DELEGATED DECISION TO DETERMINE PLANNING APPLICATIONS

Reference No:	2023/62/93561/E
Site Address:	20C, North Road, Kirkburton, Huddersfield, HD8 0NX
Description:	Engineering operations to form vehicular access
Recommending Officer:	Nicole Helliwell

Officer Report

Cross section A – Proposed Levels A-A

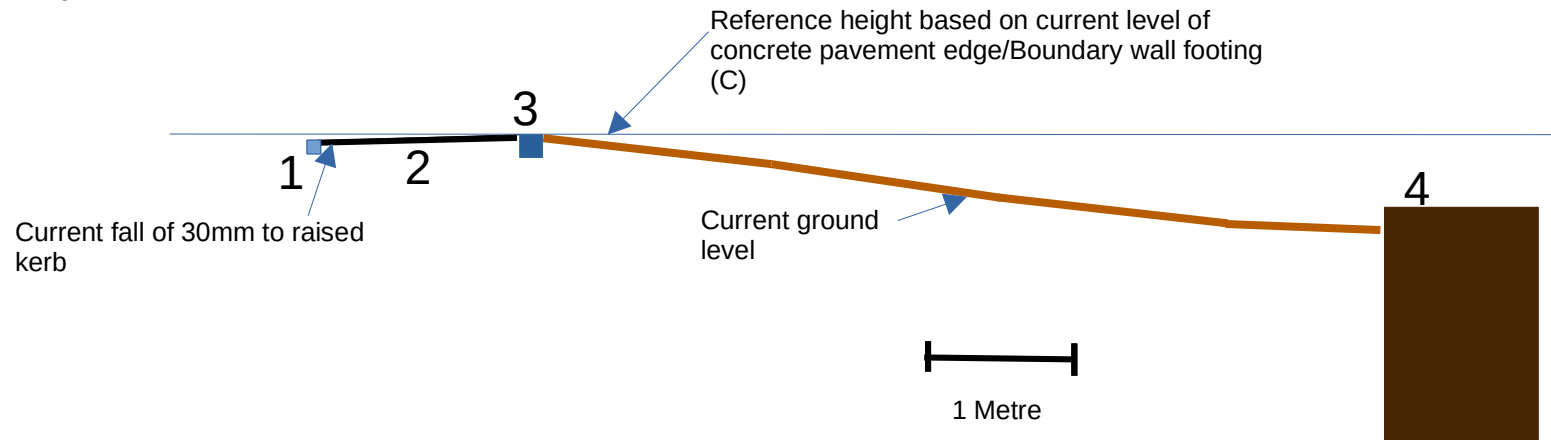
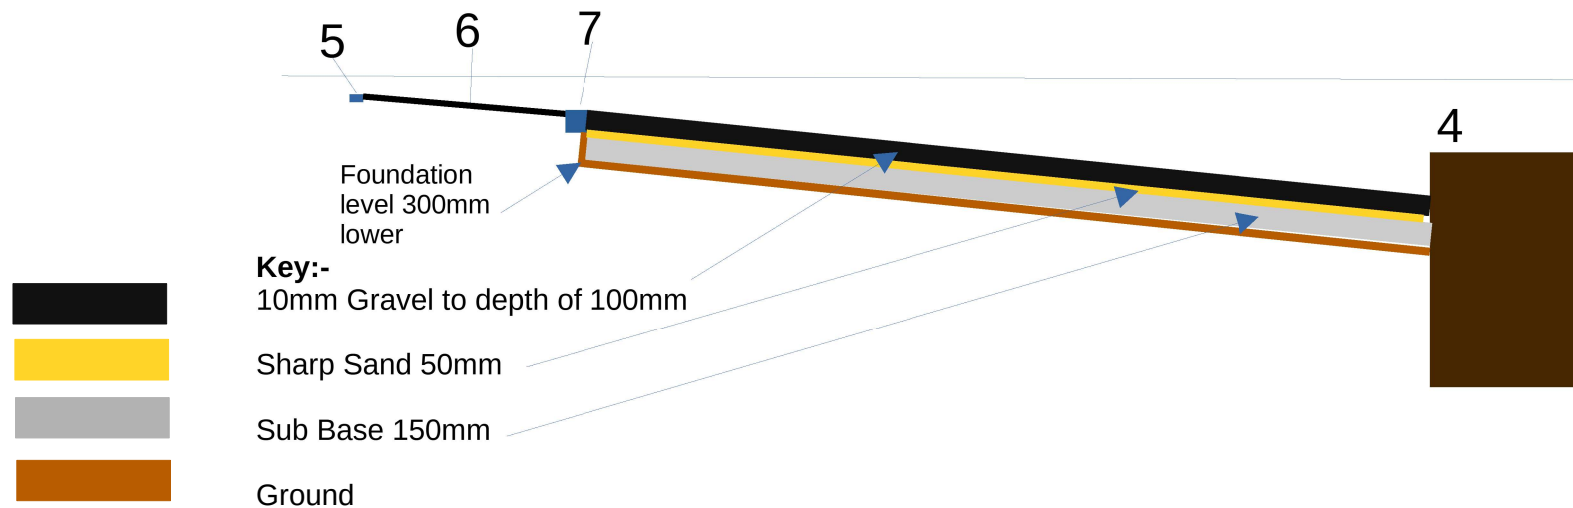
The Parish Council has concerns about the proposed development as the site is adjacent to the entrance to what has become known as Burton Community Field, which has become a valuable asset to the local community especially during lockdown. It is important in enhancing the woodland and appearance of the entrance to the Community Field. The proposal appears to miss the existing

mature trees on the site. However, their roots are likely to be damaged when exposed and by the use of a wacker plate during construction so it is requested that Kirklees Council's Tree Officer is consulted and any subsequent work be carried out by a qualified tree surgeon. Secondly, a caravan parked permanently in the wood will detract from the appearance of the entrance to the field, so it is suggested that a native hedge be planted to screen it from the road and field. This will also enhance the security of the caravan.

Reason: This detail is required prior to development commencing on site to protect the viability of the existing trees within close proximity to the application site and to accord with Policy LP33 of the Kirklees Local Plan and the National Planning Policy Framework.

5. Development shall not commence until an Arboricultural Method Statement, has been submitted to, and approved in writing by the Local Planning Authority. The method statement shall include details of including but not limited to the following:

SitePlan Showing visibility splay

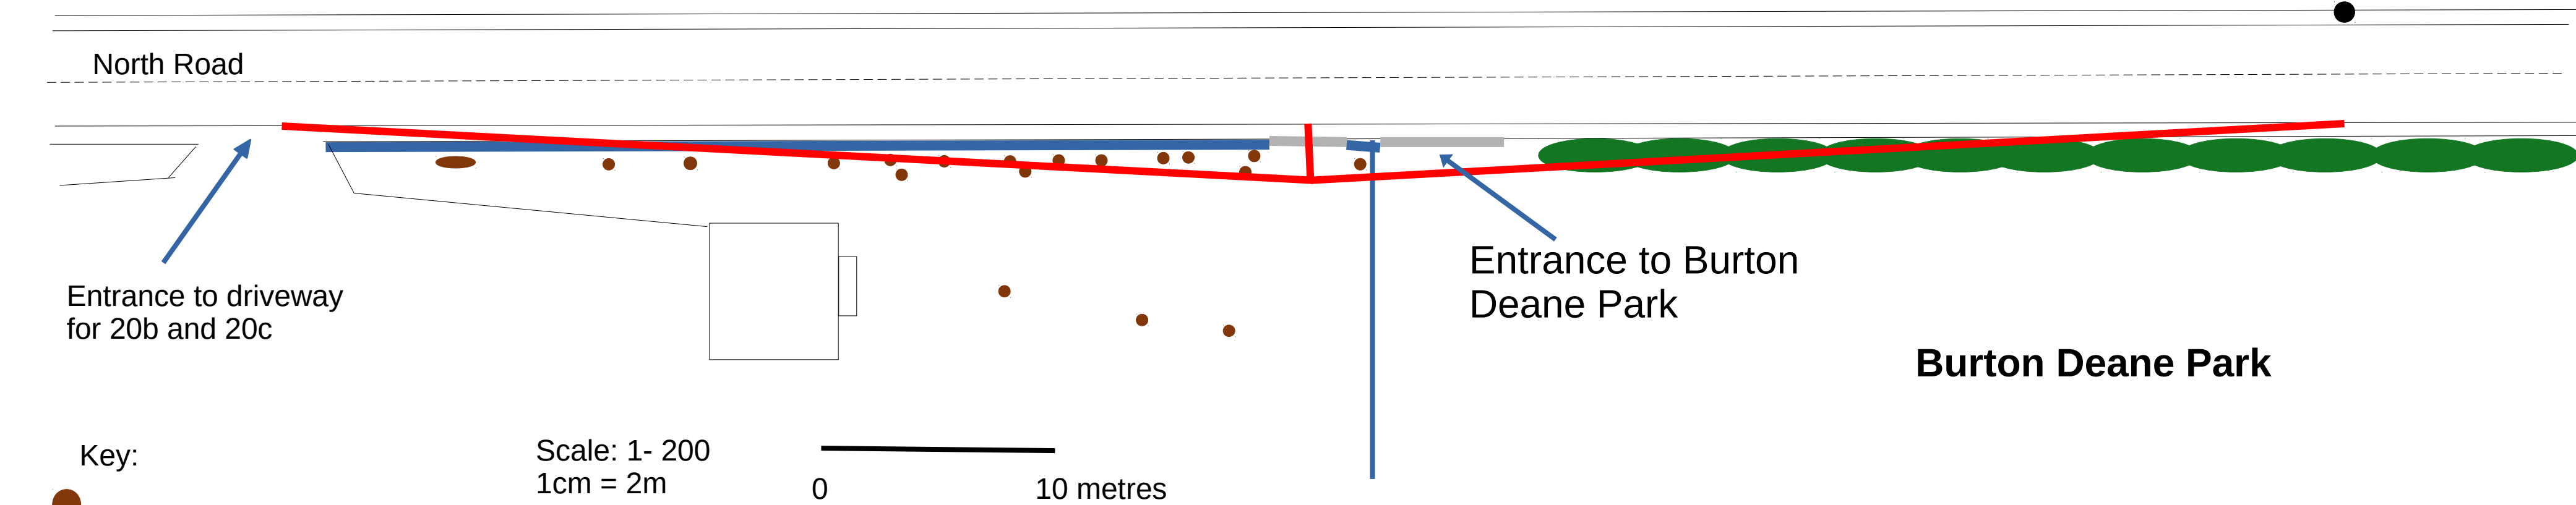
The proposed development would not intensify the domestic use at the dwelling or affect the existing parking arrangements on site. KC Highways were informally consulted on the proposed scheme and did ask the applicant to demonstrate that visibility splays of 2.4m x 43m can be achieved on site. A drawing was submitted in this regard which was considered acceptable by KC Highways.

Further information was sought during the course of the application. Following an informal consultation with KC Highways, a request was made to demonstrate that visibility splays of 2.4m x 43m could be achieved. A drawing

was submitted in this regard which was considered acceptable by KC Highways.
